WEST SUSSEX COUNTY COUNCIL CONSULTATION

TO:	Arun District Council FAO: Mr. S. Davis
FROM:	WSCC Highways - Public Rights of Way
DATE:	7 March 2022
LOCATION:	Land to the south of Ford Lane and east of North End Road Yapton BN18 0DS
SUBJECT:	Y/10/22/PL Erection of 15 No dwellings (including 4 No affordable units) with associated access, parking, landscaping, drainage and public open space (additional units to those approved under application Y/123/21/PL). This application may affect the setting of a listed building, affects the character & appearance of the Church Lane Conservation area, affects a Public Right of Way and is in CIL Zone 2 and is CIL Liable as new dwellings.
DATE OF SITE VISIT:	n/a
RELEVANT PUBLIC RIGHTS OF WAY NUMBER(S):	FP358
RECOMMENDATION:	More Information
S106 CONTRIBUTION TOTAL:	n/a

Drawing Title
Sections through public right of way footpath 358 and 359

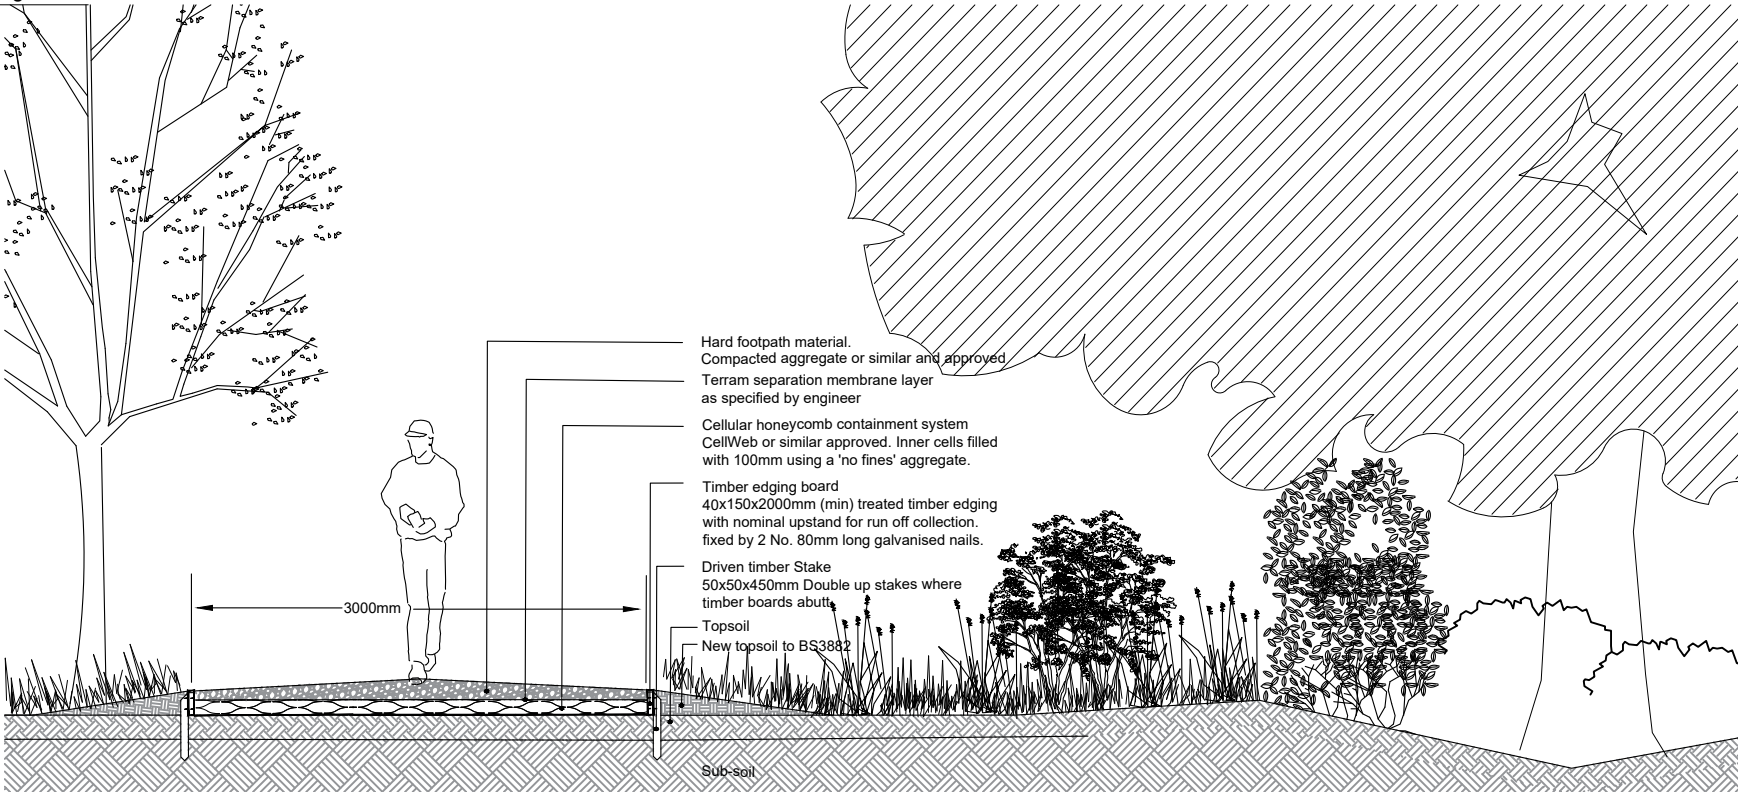
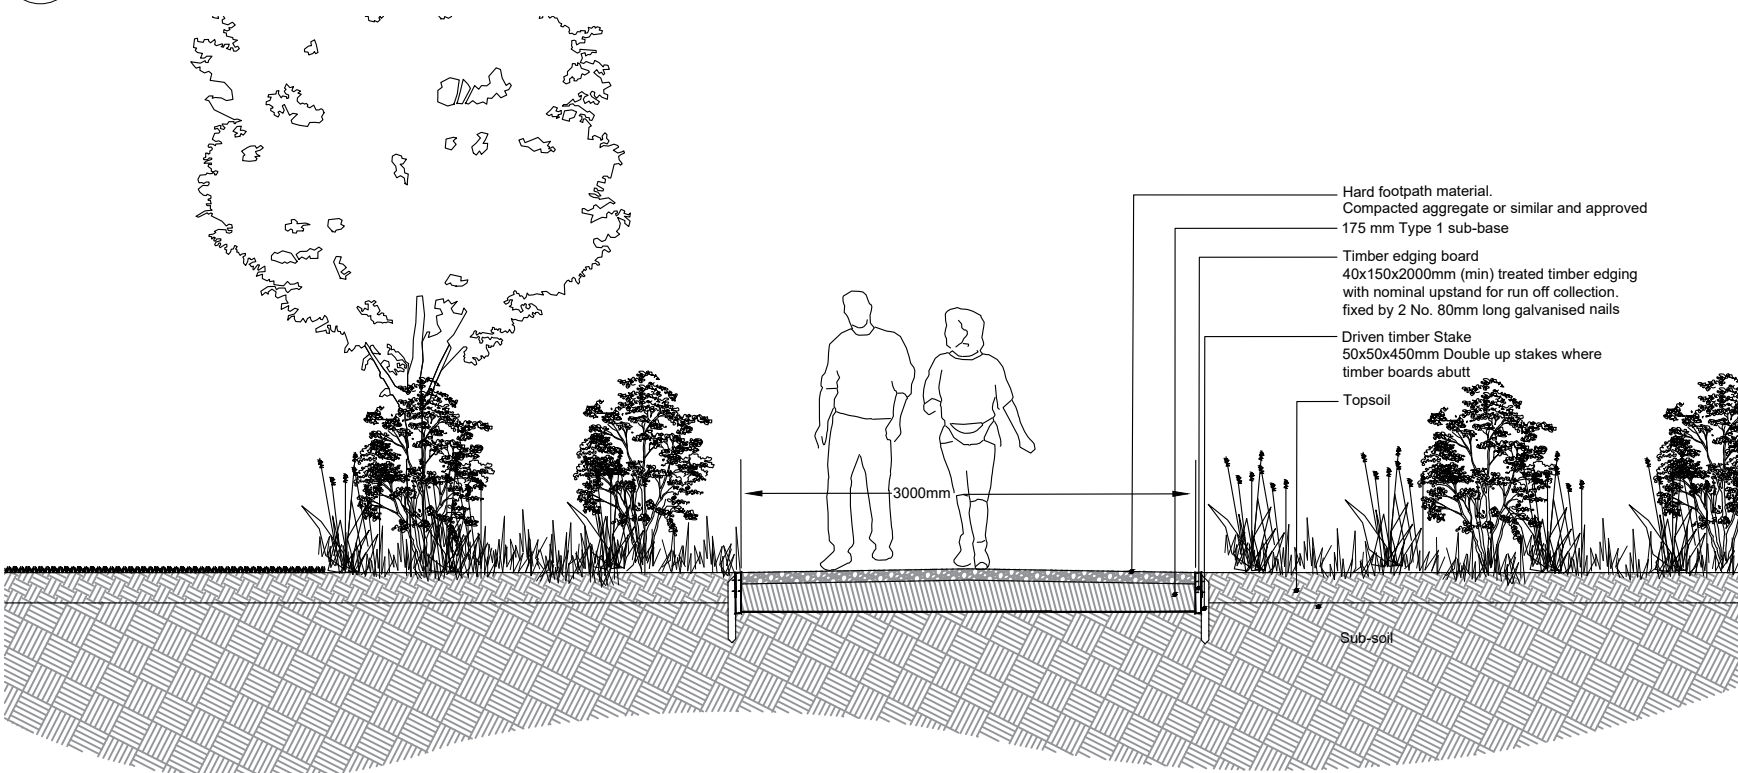
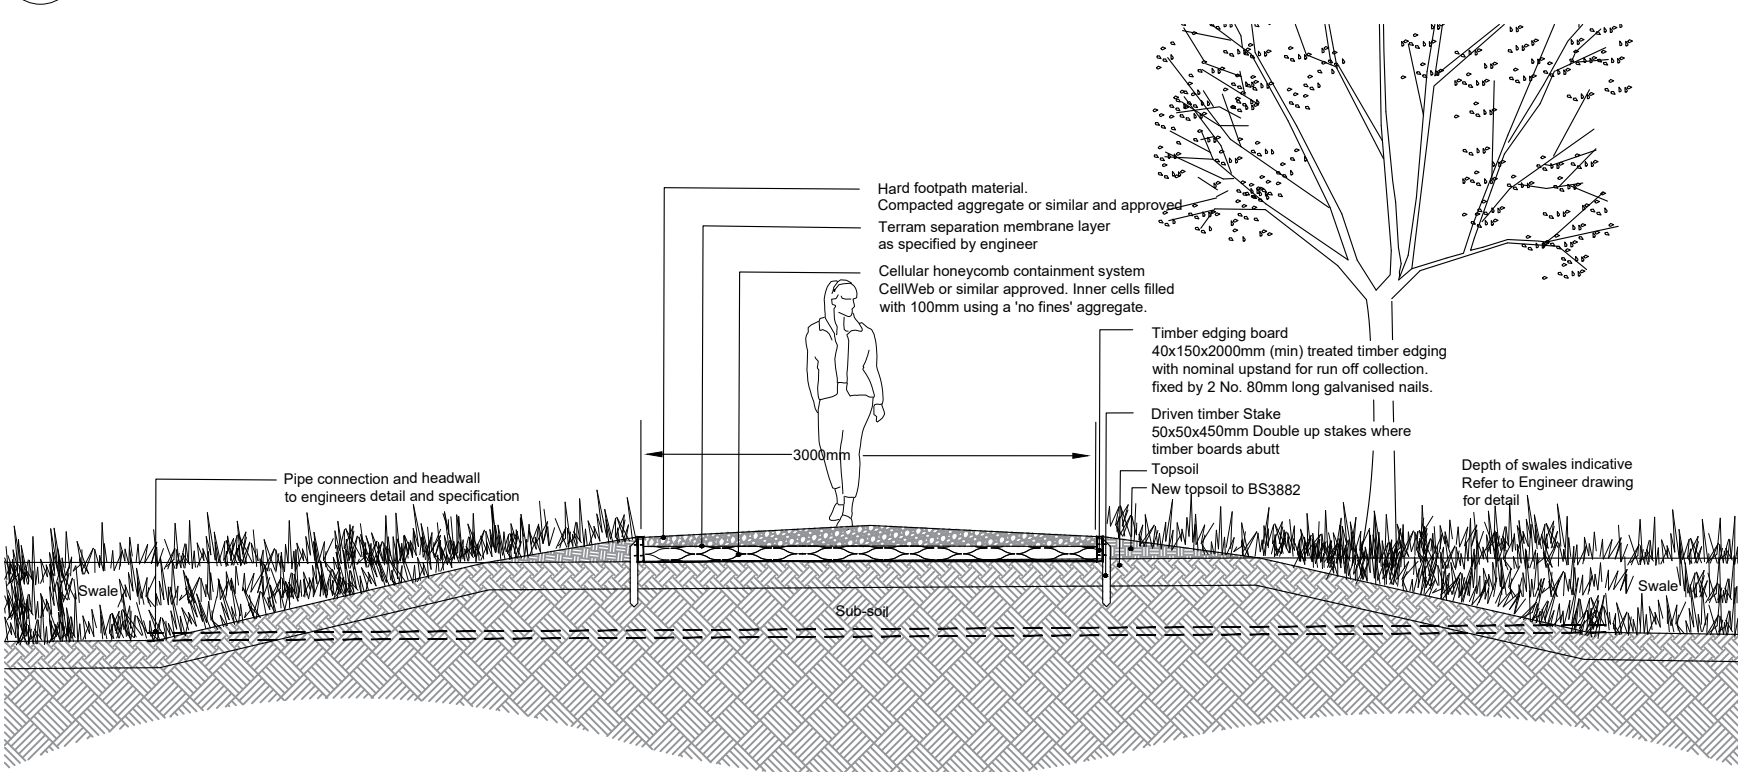
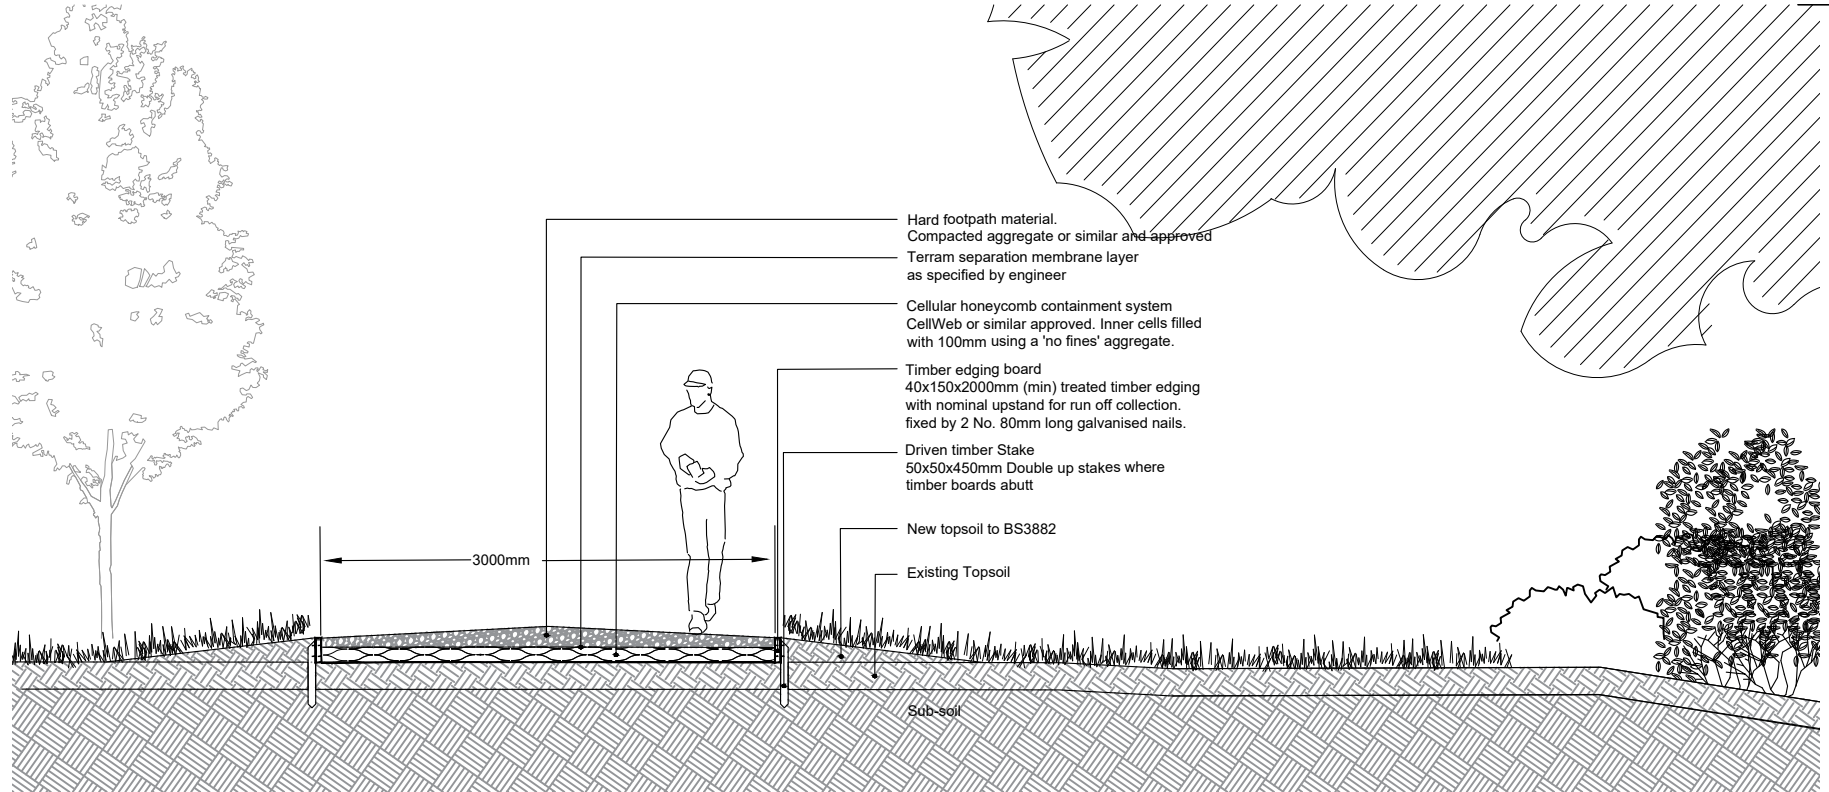
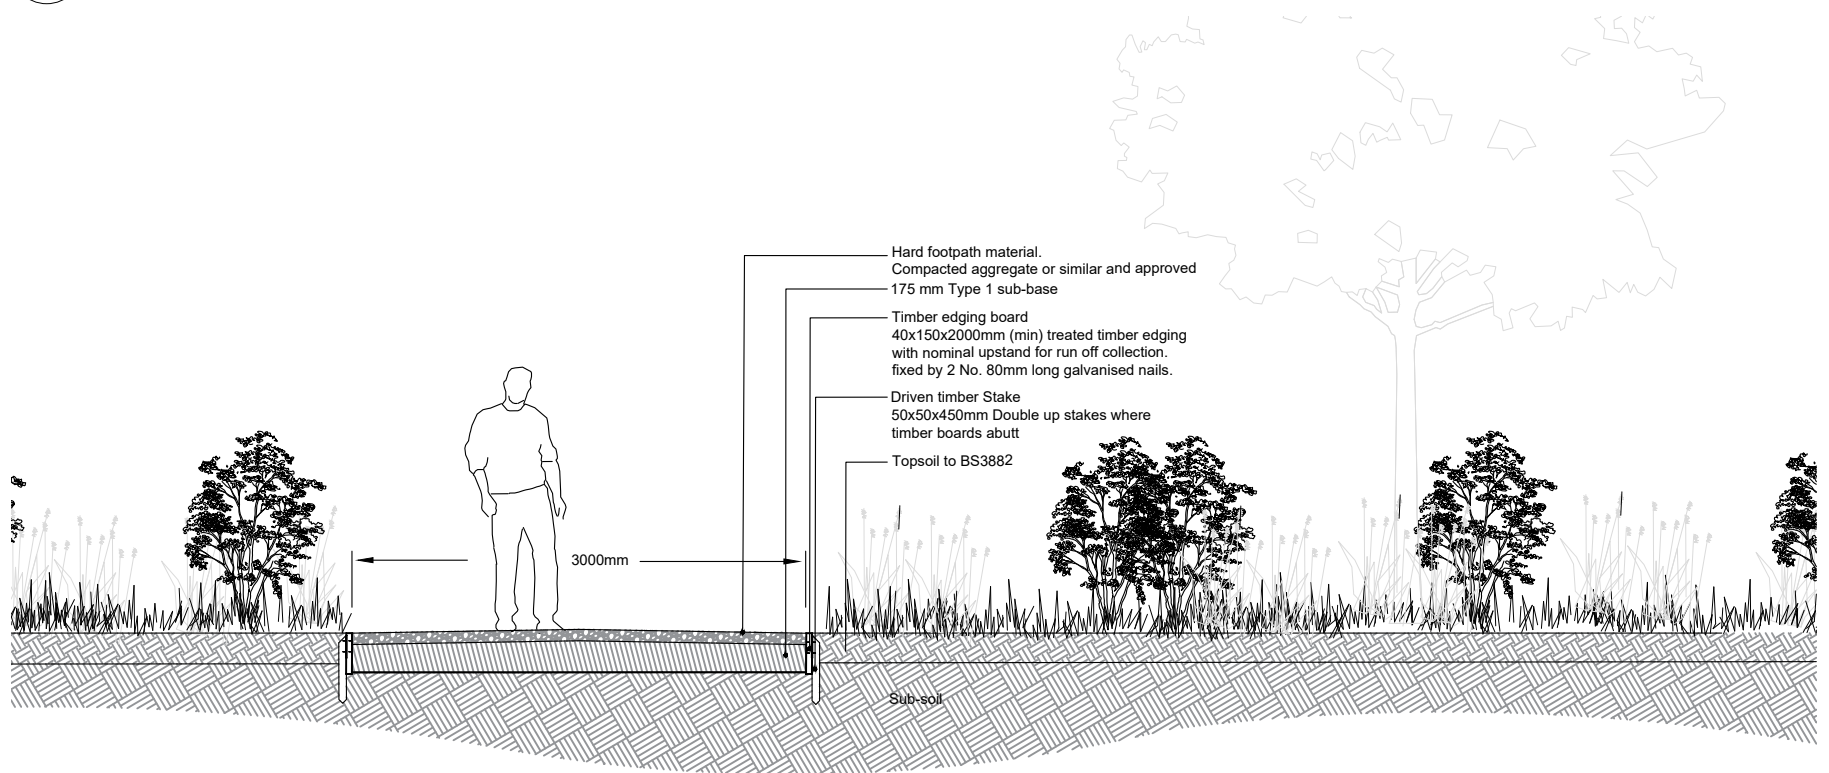
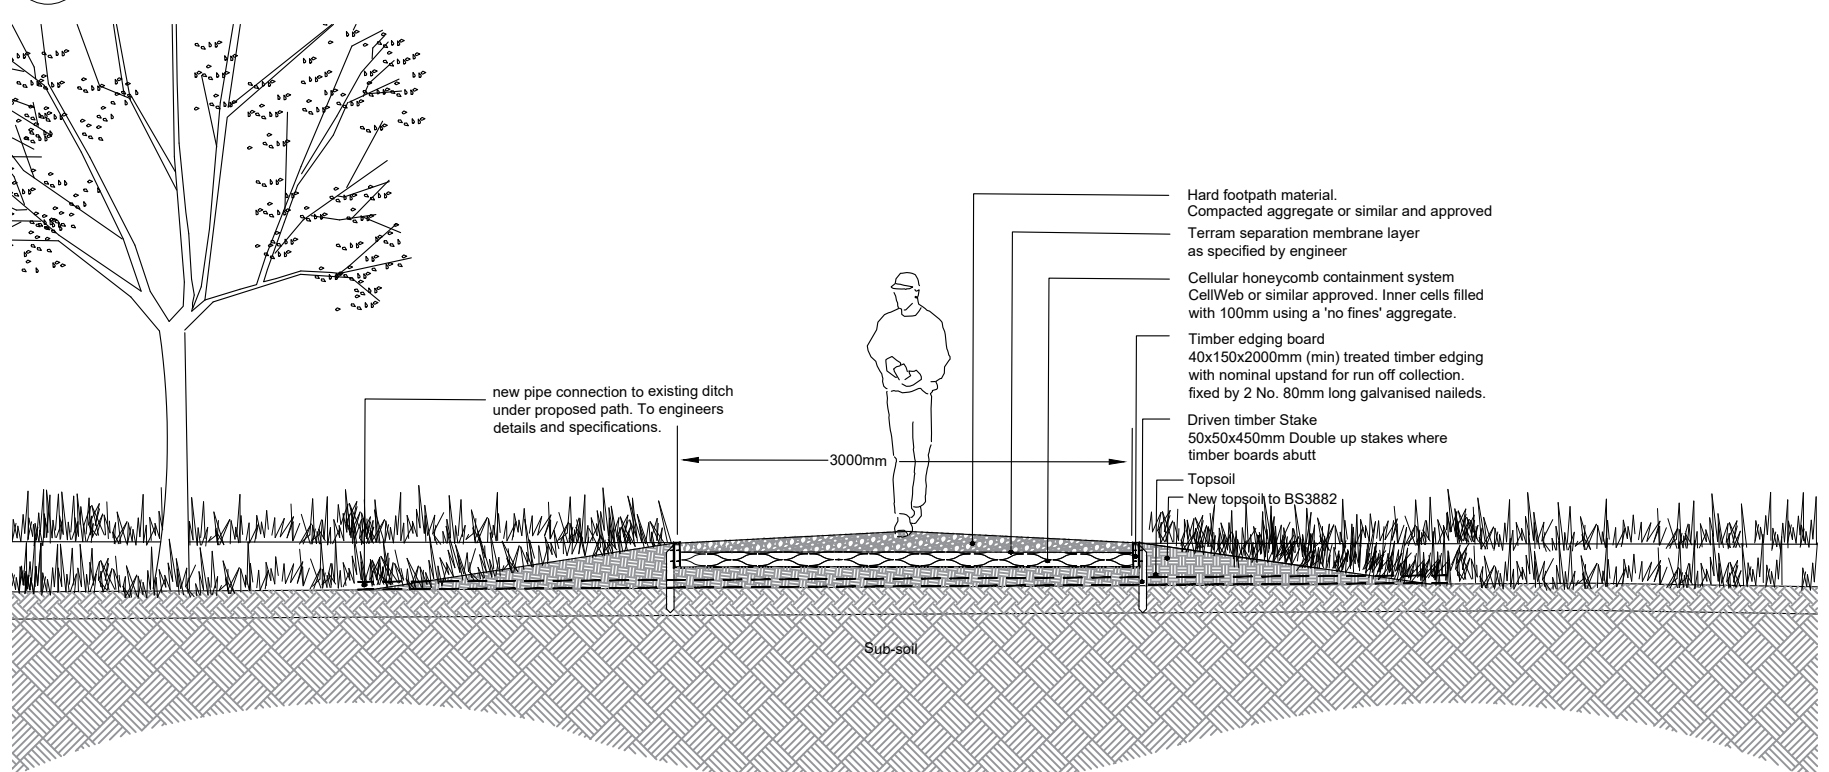
From the documents available this appears to refer to the resurfacing of FP358 along the eastern edge of the development site and FP357 (as discussed below). This was previously commented on in relation to Y/123/21/PL and looking at the proposed drawings including surface specification and widths I can confirm we have no objection to the surfacing and widths of FP358.
